OFFICIAL NOTIFICATION OF DECISION

Project# PR-2024-010189
Application#
BULK_PLT-2025-00001 BULK LAND PLAT

**TRACT N-1, CORRECTION PLAT OF TRS N-1
& N-2 WATERSHED SUBD zoned PC**
located at **9601 TIERRA PINTADA BLVD**
between **TIERRA PINTADA BLVD NW and**
ARROYO VISTA BLVD NW containing
approximately **109.9839** acre(s).
(H-08, J-08, & J-07)

PR-2024-010189 April 9th, 2025 Notice of Decision - DHO

PLAT OF
TRACTS N-1-A & N-1-B
WATERSHED SUBDIVISION
(A REPLAT OF TRACT N-1,
WATERSHED SUBDIVISION)
PROJECTED SECTIONS 17 AND 18,
TOWNSHIP 10 NORTH, RANGE 2 EAST,
N.M.P.M.
ALBUQUERQUE,
BERNALILLO COUNTY, NEW MEXICO
AUGUST, 2023

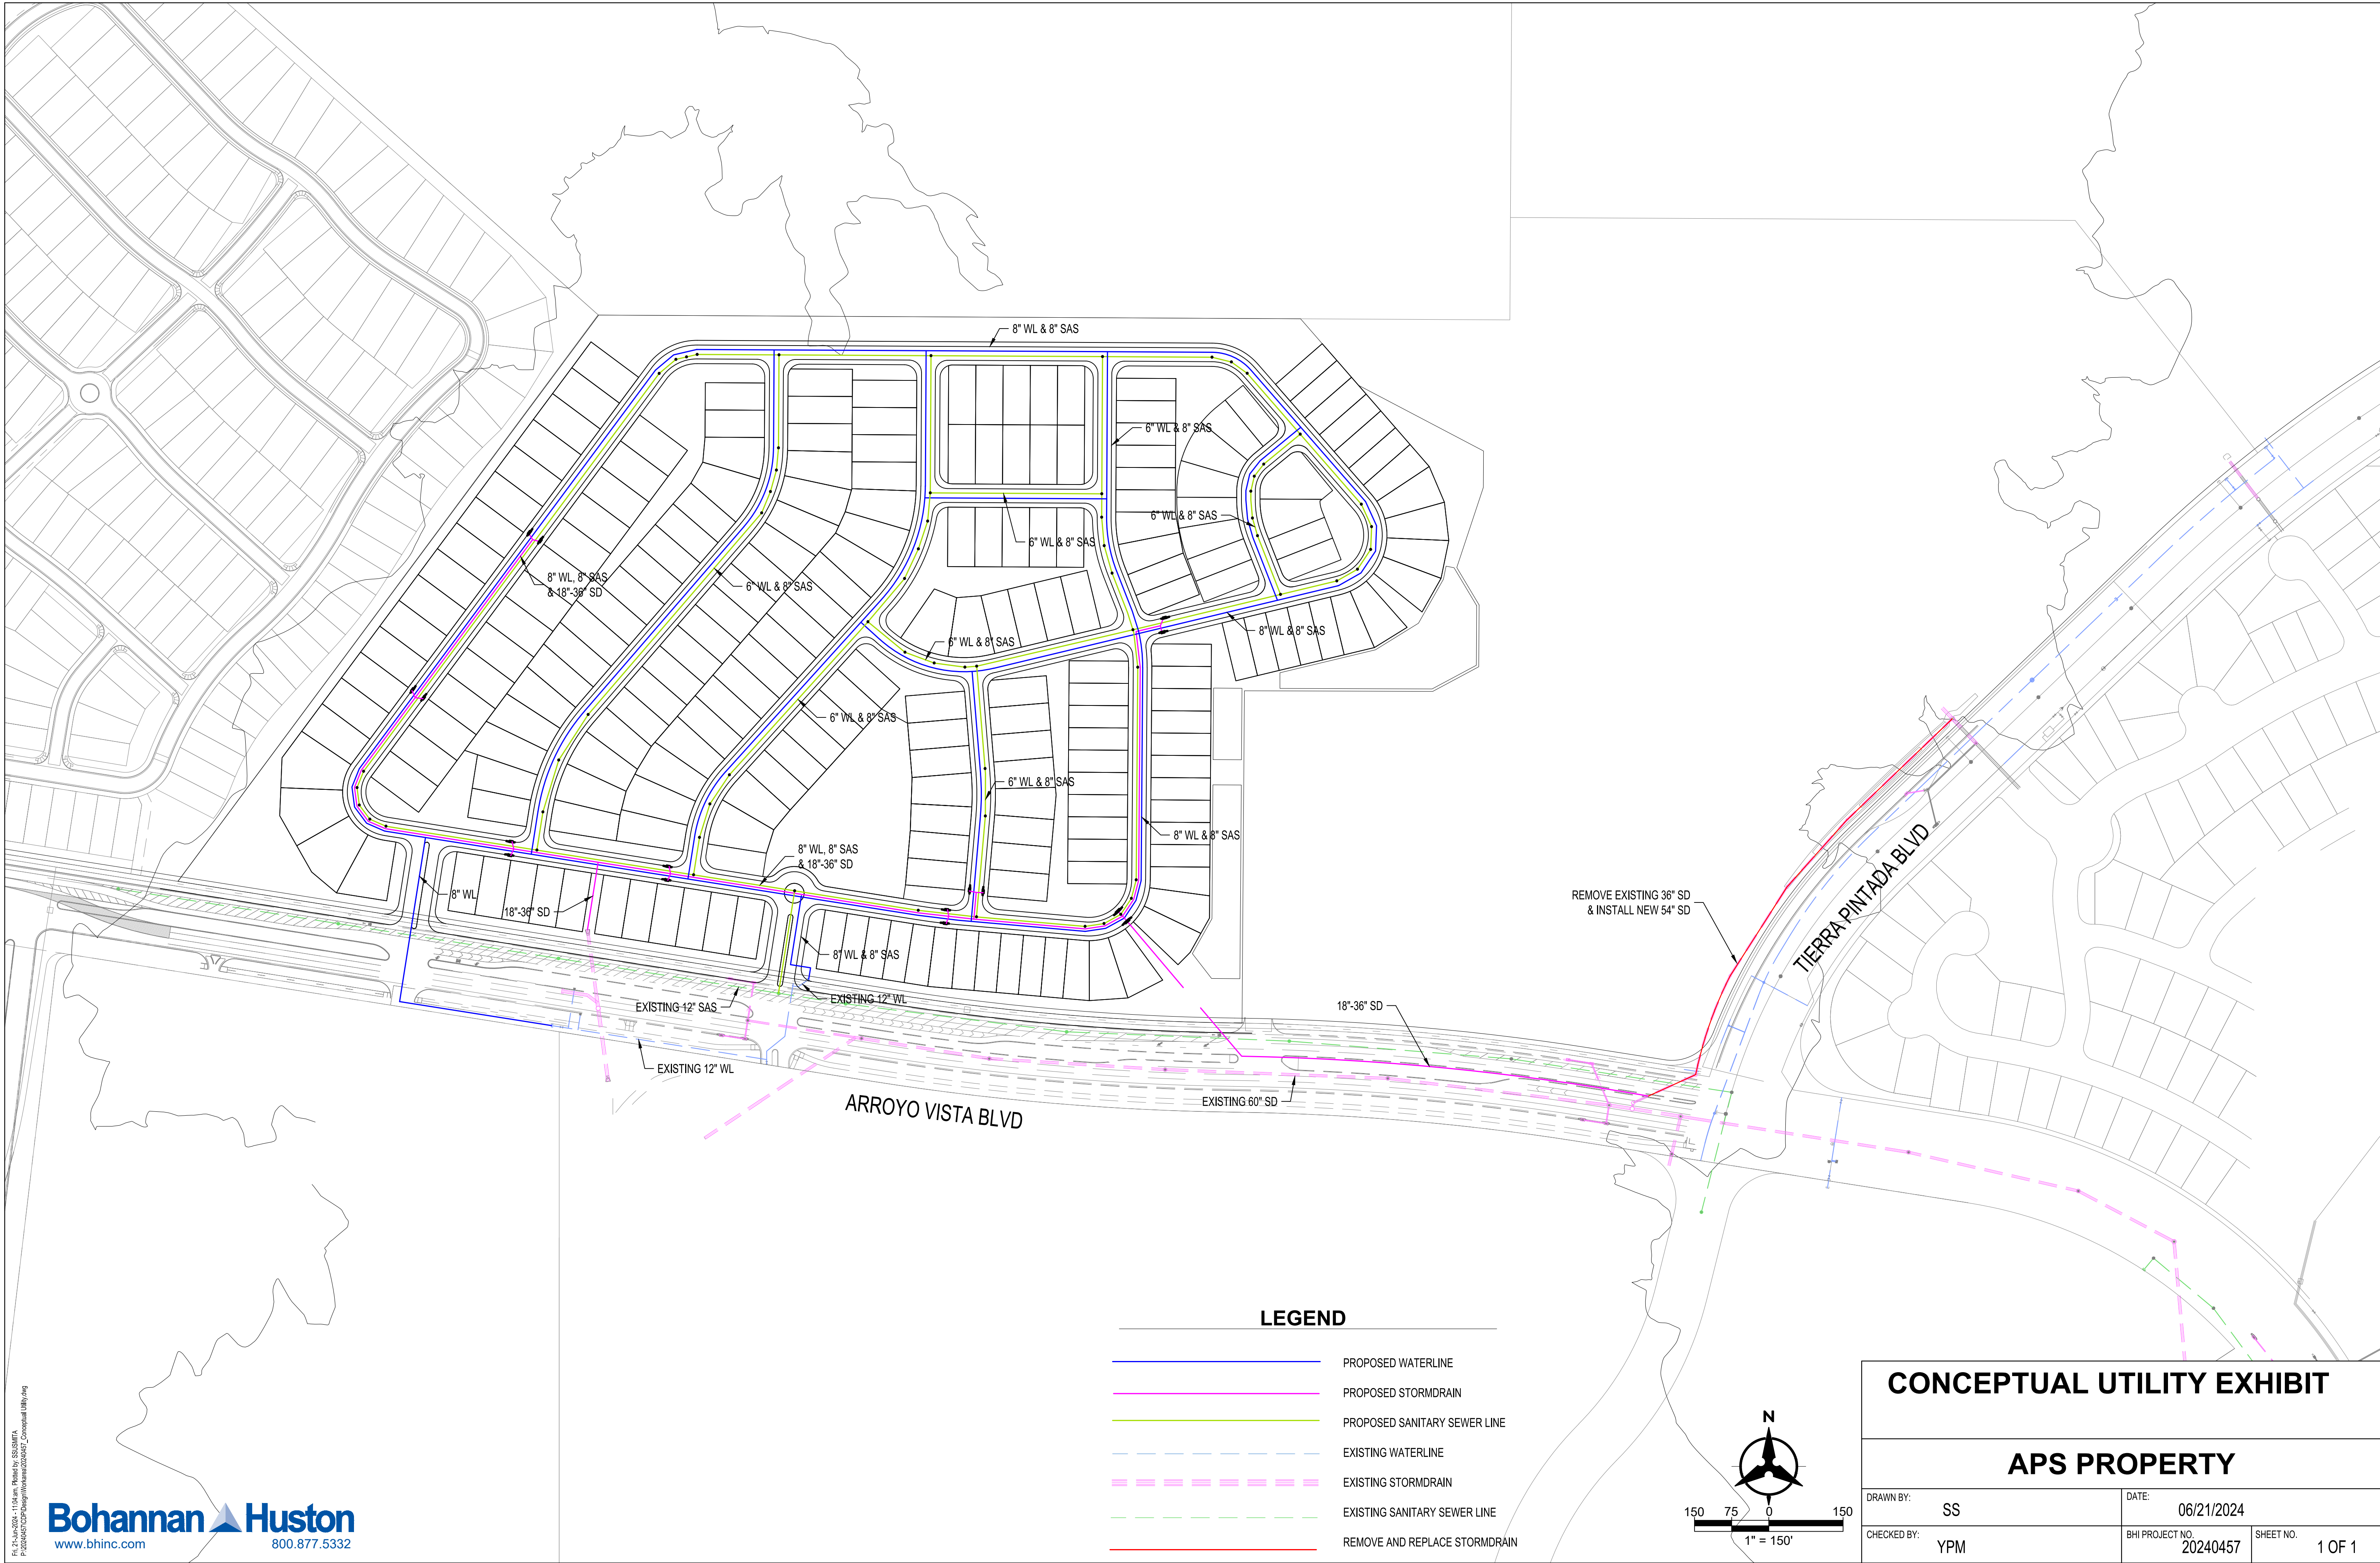
- a. Provide a 20' public waterline easement that will provide access to the public waterline for proposed Tract N-1-B across proposed Tract N-1-A configured to accommodate a public waterline connection for the proposed future development.
